**West Yorkshire Police
Kirklees District**

| To: Rebecca Drake | Ref: 2019/90443 Date: 5 th April 2019 |

Site Location: 316 Middle Road, Earlsheaton, Dewsbury, WF12 8BT

Application Type: Dwelling conversion to 9 apartments

Proposed Lower Ground Floor Plan 1:100

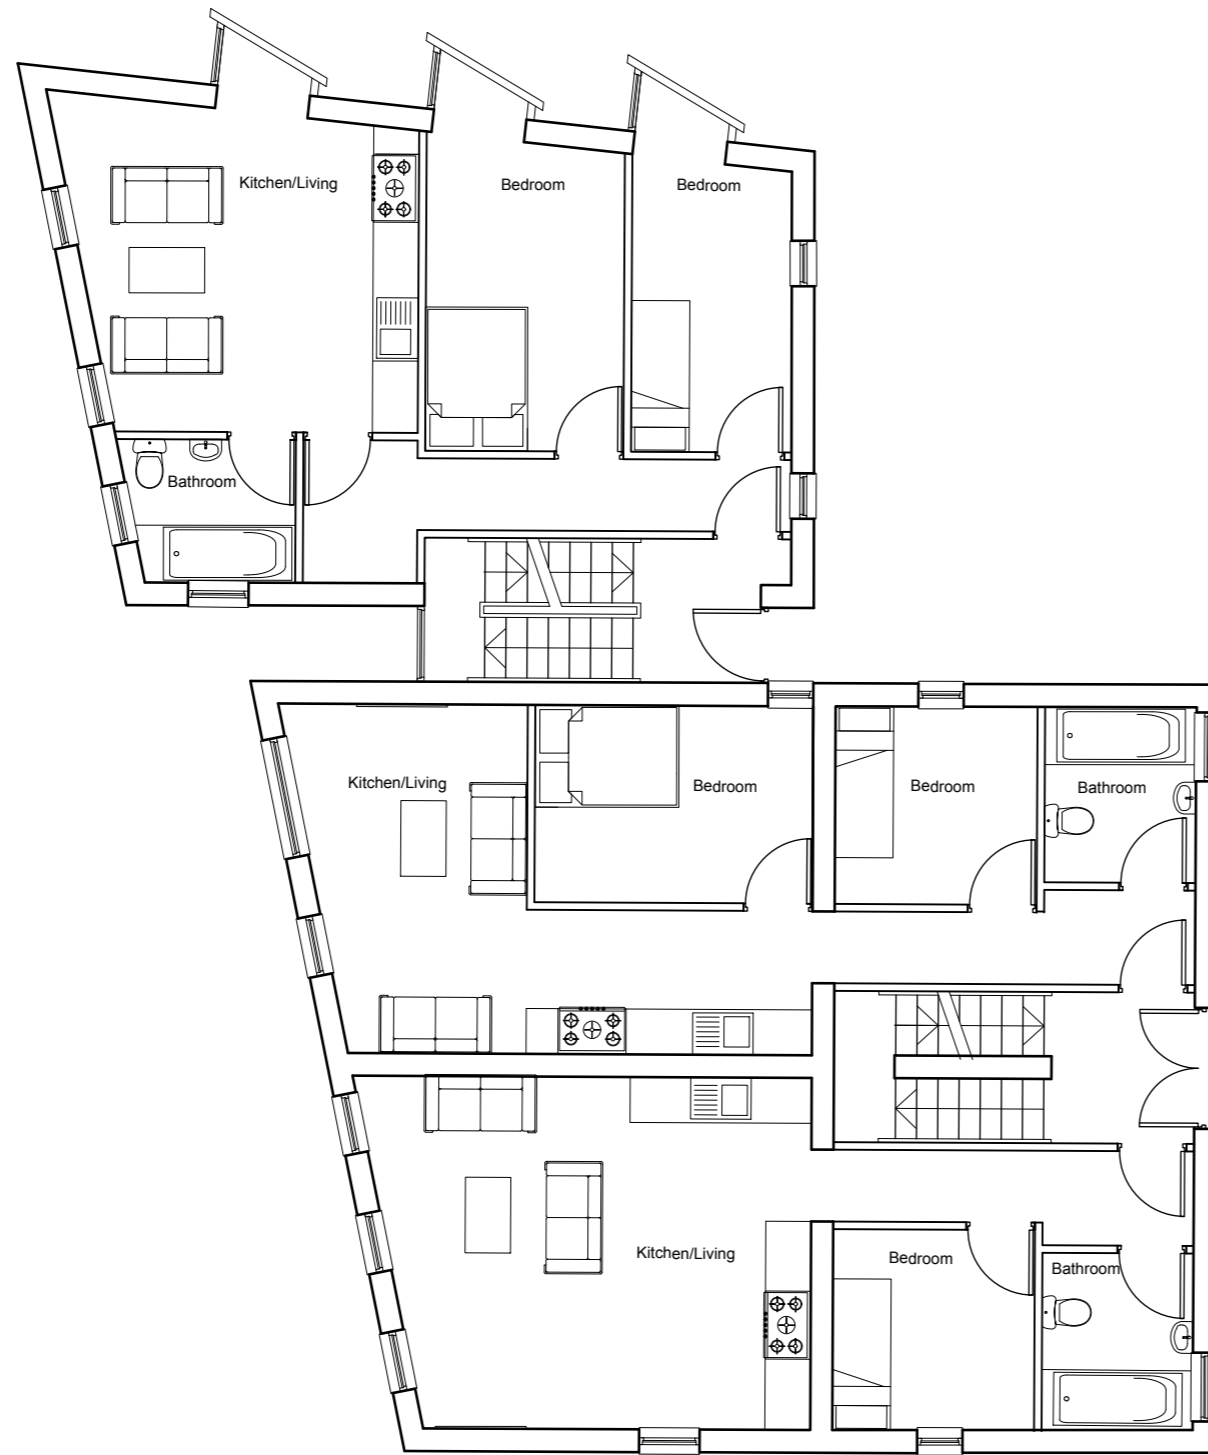
Looking at the above plans and the **proposed visuals document 2018-281**, I would recommend the rear lower ground floor external terrace is either removed or defended from external access from across the greenspace to the sides and rear of the building . Boundary treatments for the terrace should be to a height of 1800mm constructed from such as masonry materials, close boarded timber fencing or other durable materials. It should be installed where there is a change in the ground level beyond the perimeter wall. In the proposed visuals, the North elevation shows the perimeter wall reducing to a small height from the greenspace. This could easily be climbed giving access to the terrace. There is a large gap in the perimeter wall on the South elevation onto the terrace. This would be an access point for an offender to attack the building at this level.

From the drawings there is no access shown from within the building onto the external terrace.

Drawing Title:
Floor Plans (1 of 2)
As Proposed
Scale: Date: Drawn: Checked:
1/100@A3 Dec 18 MS
Drawing Number: Revision:
2018-281-006

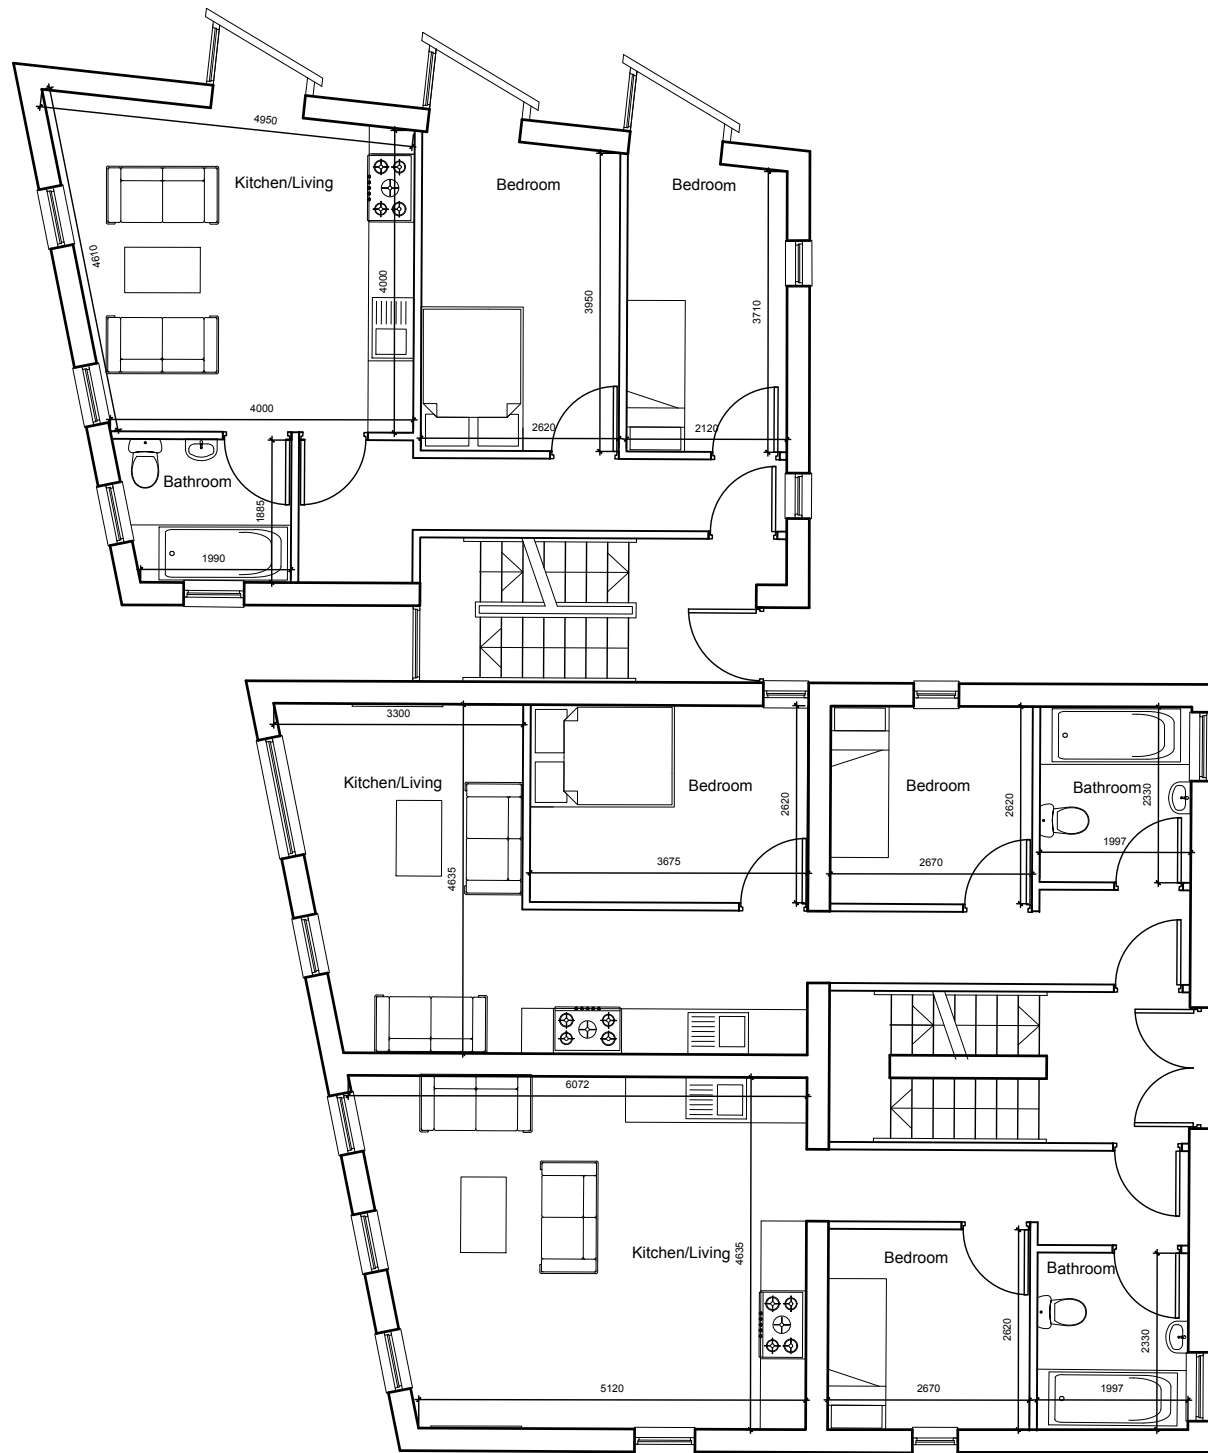
From the East elevation to the front entrance of the property, the Northern block entrance is shown as being on the ground floor from drawing number **2018-281-006**. This is not clear in the proposed visuals of this elevation. Could it be confirmed that the North block entrance is actually on the ground floor level and not the lower ground floor. Should the preferred entrance be on the lower ground floor, it is advised that access controlled gates and open aspect fencing such as close link welded mesh fencing is installed. This would create defensible space and make sure that natural surveillance of the entrance is not compromised.

Drawing Title:
Elevations (1 of 2)
As Proposed

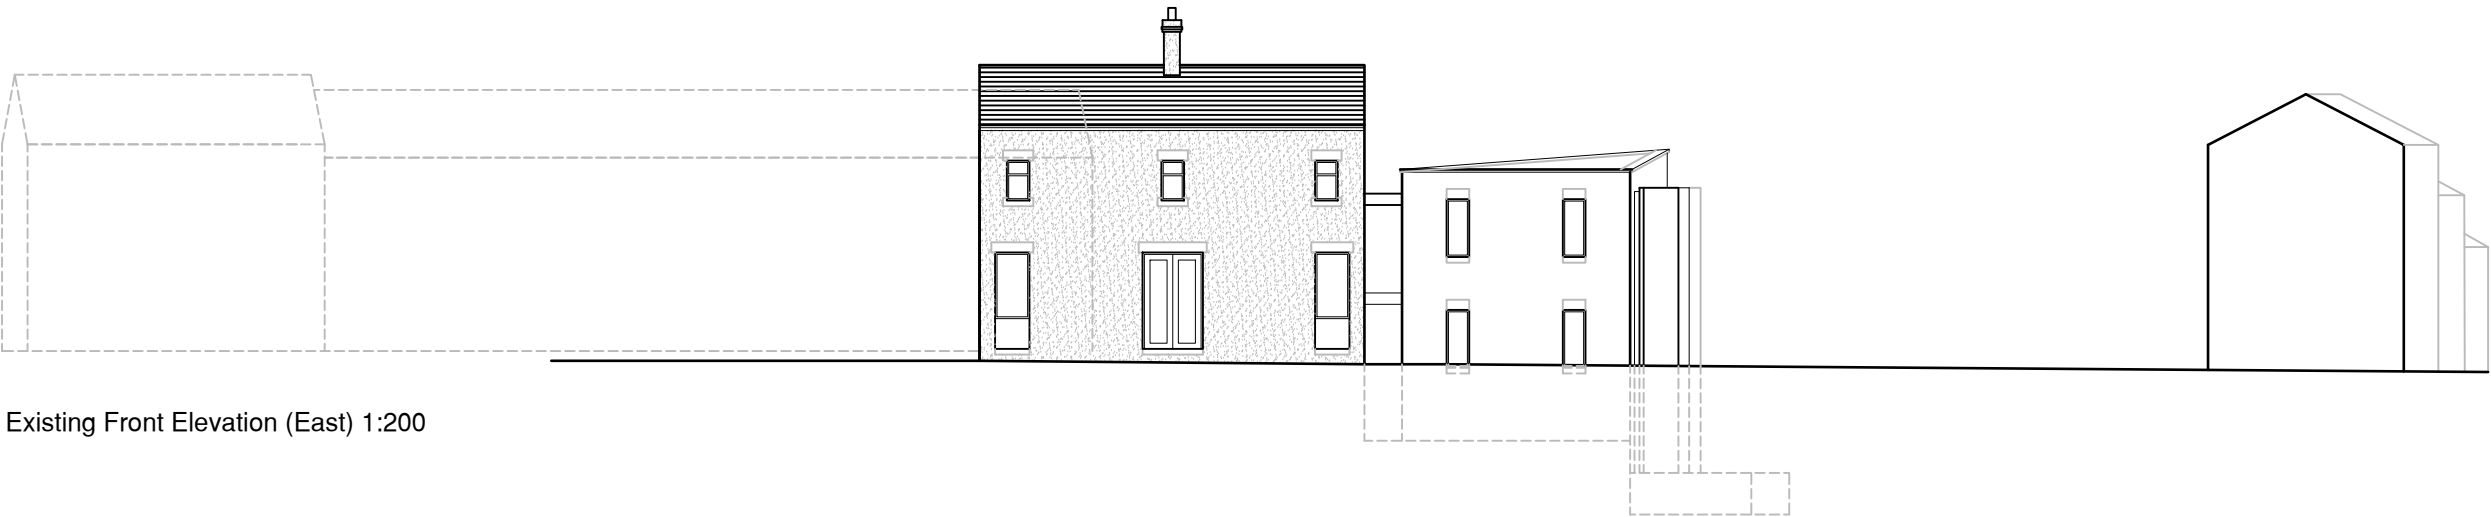
There is a deep recess shown between the two sections of the building on the West facing elevation. There would be direct access from the terrace to the lower ground floor bathroom window of the Northern most block. The recess would provide a considerable amount of cover for offenders to commit crime on the building. I would advise that this recess is removed by bringing the building line flush with the West elevation.
